Application no: H18/1171/00

Description: Garage

Location: 96 New Road  
Sutton Bridge  
Spalding  
Lincs

Amendment: Alterations to window in northern wall  
Dwg. No. SD00-049/1

SD00-049/1

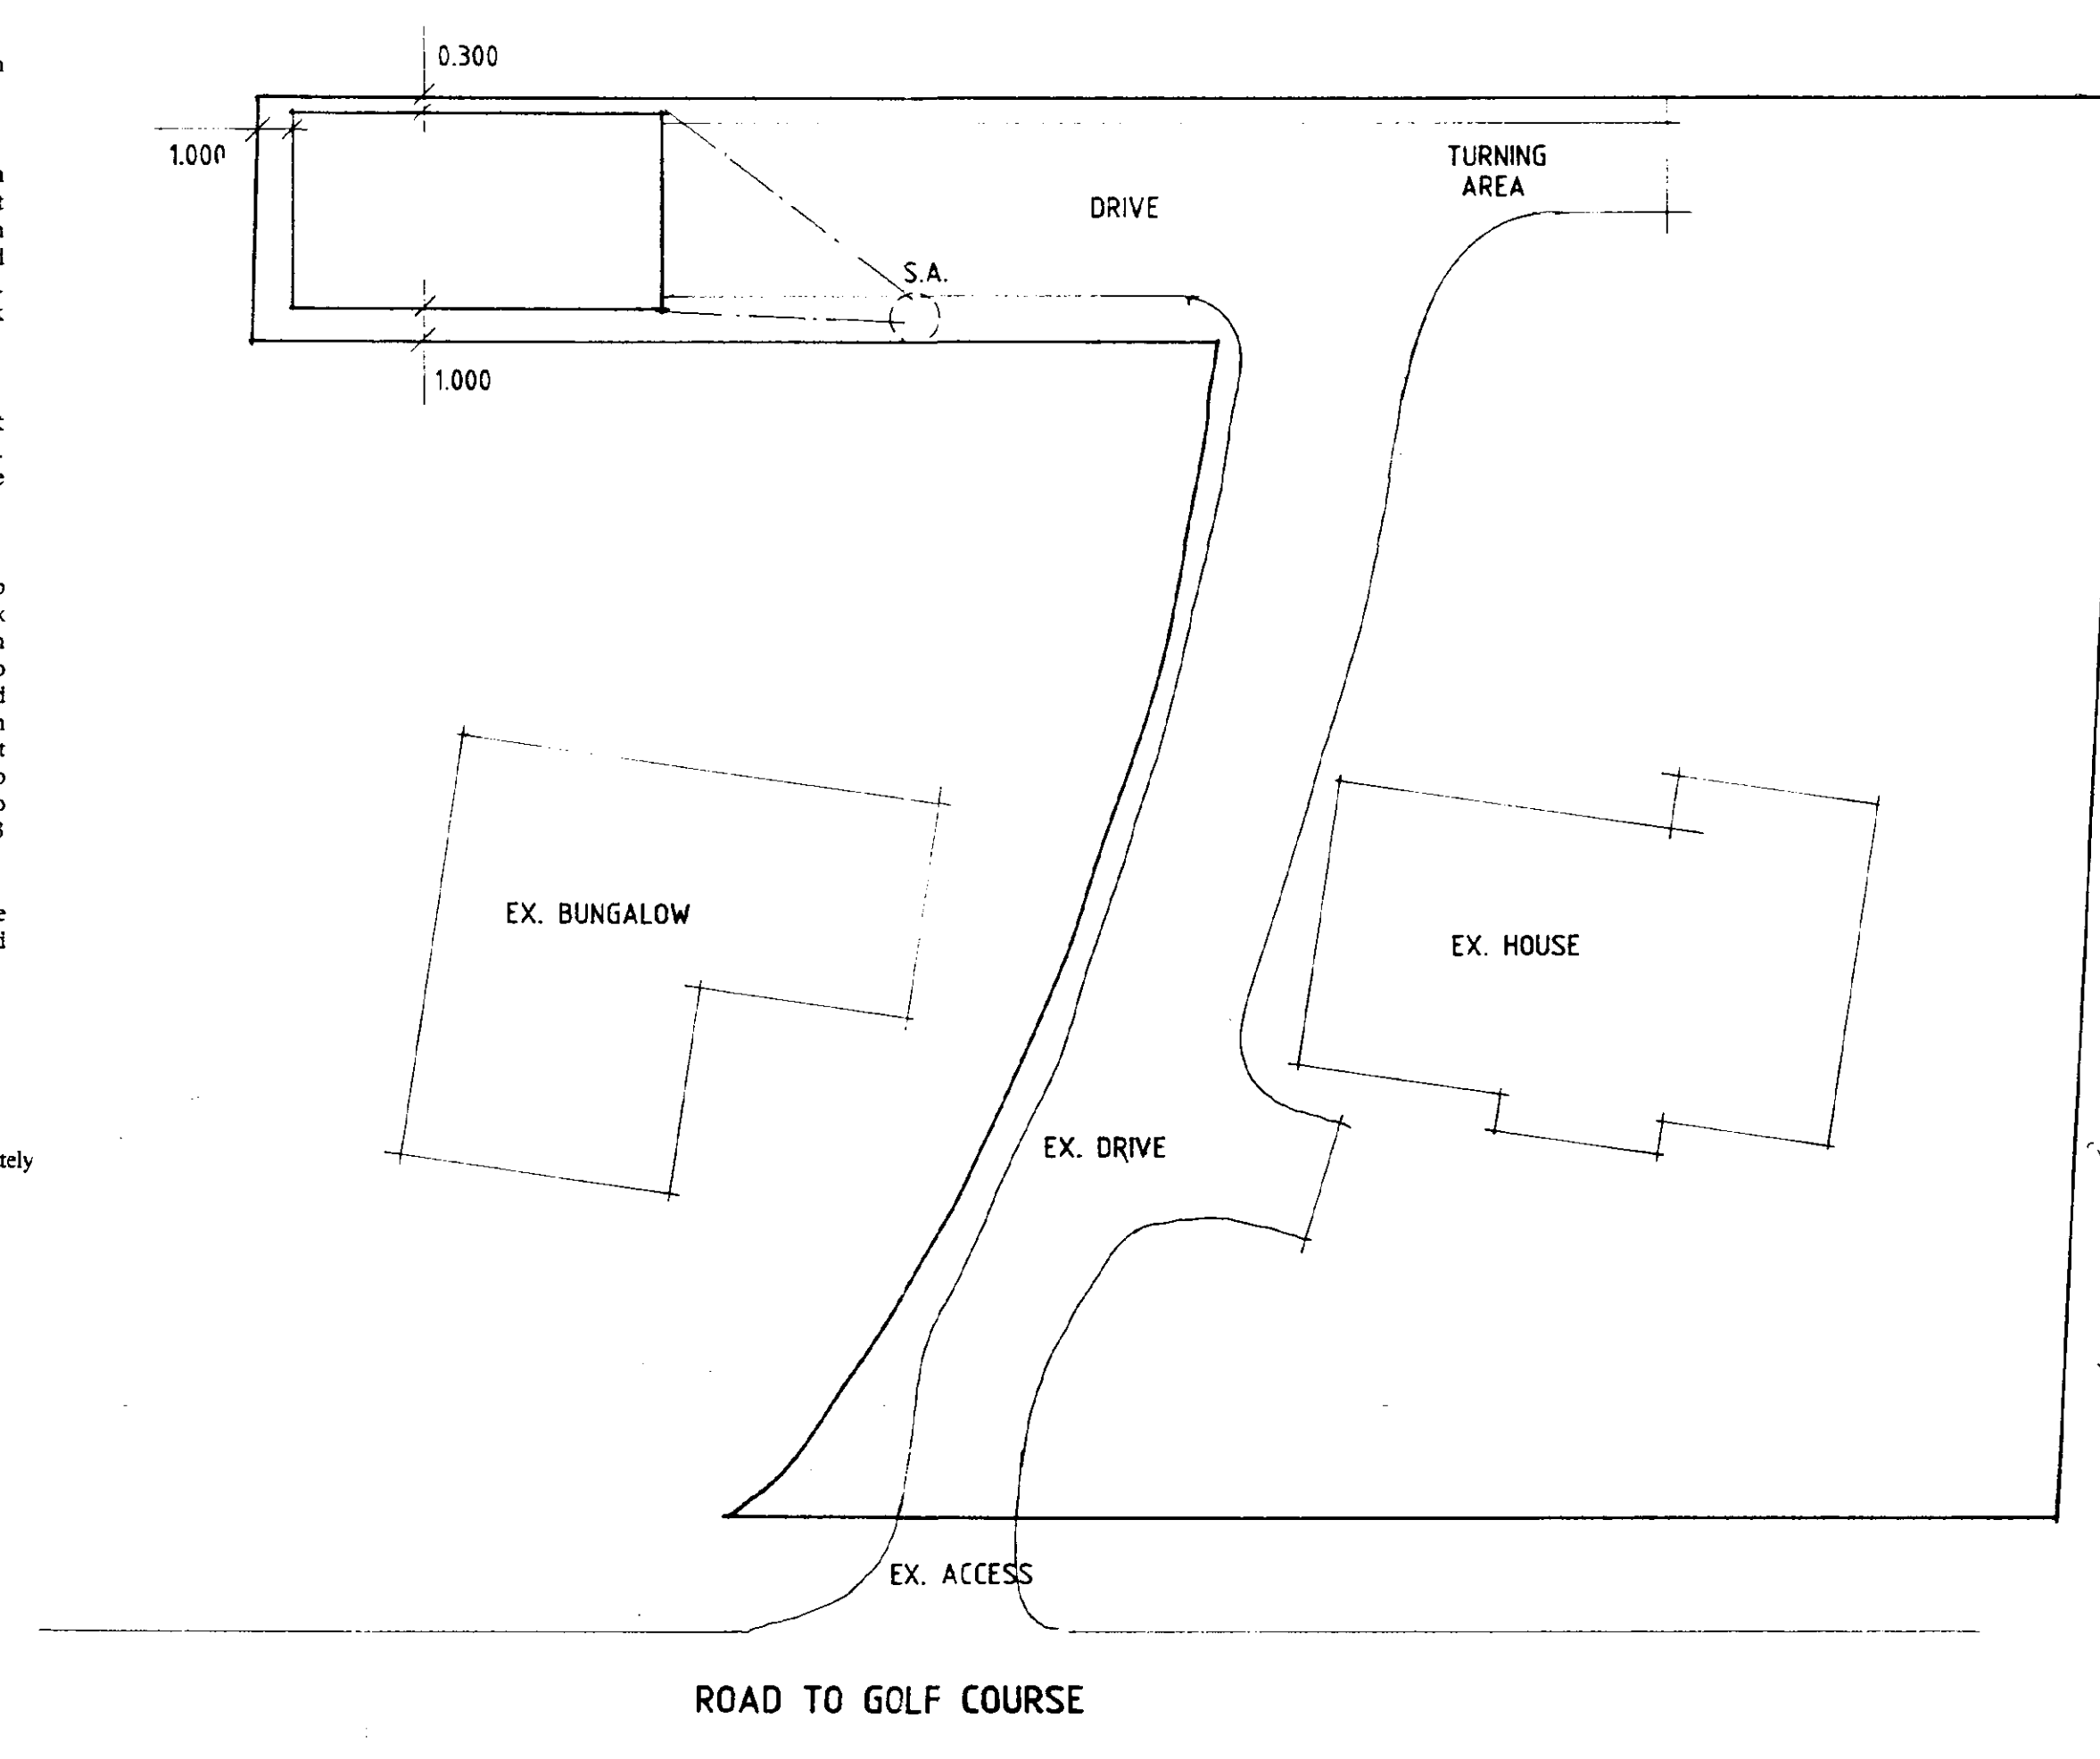
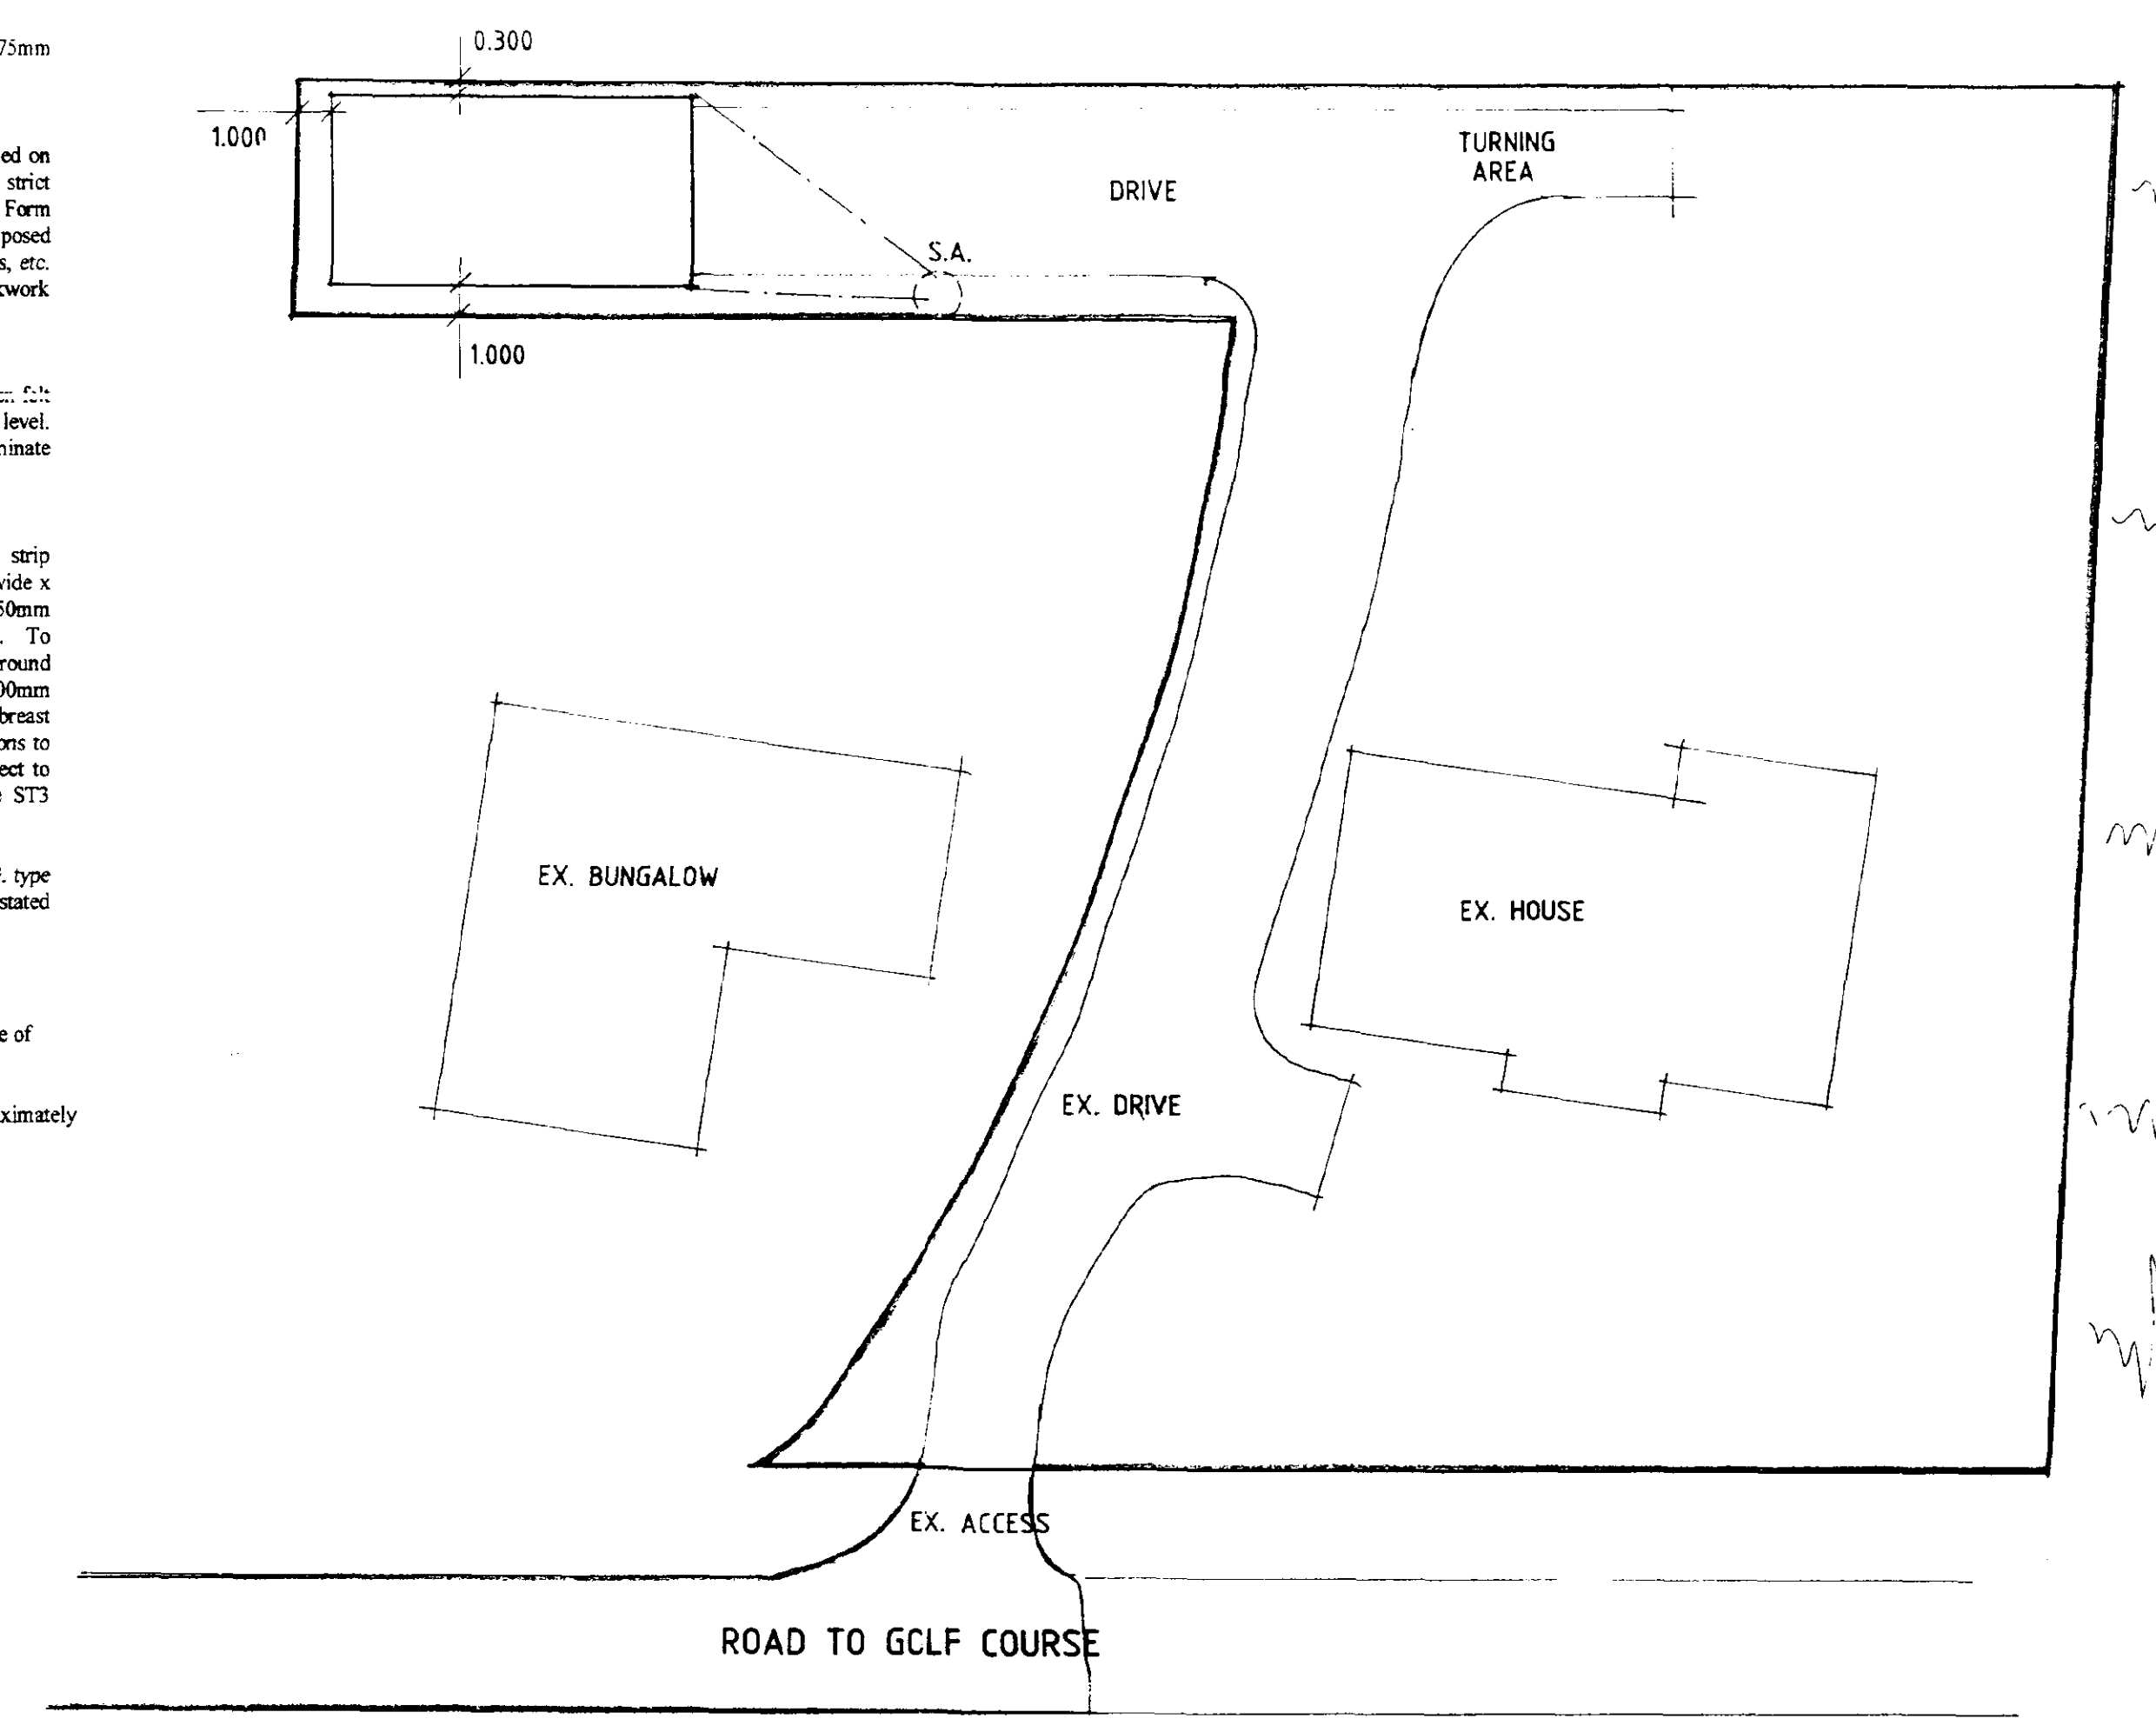
(Give a full detailed list of the changes, and  
also mark these clearly on the accompanying plans.  
Only the changes listed here will be considered.)ALTERATIONS TO WINDOW  
IN NORTHERN WALL
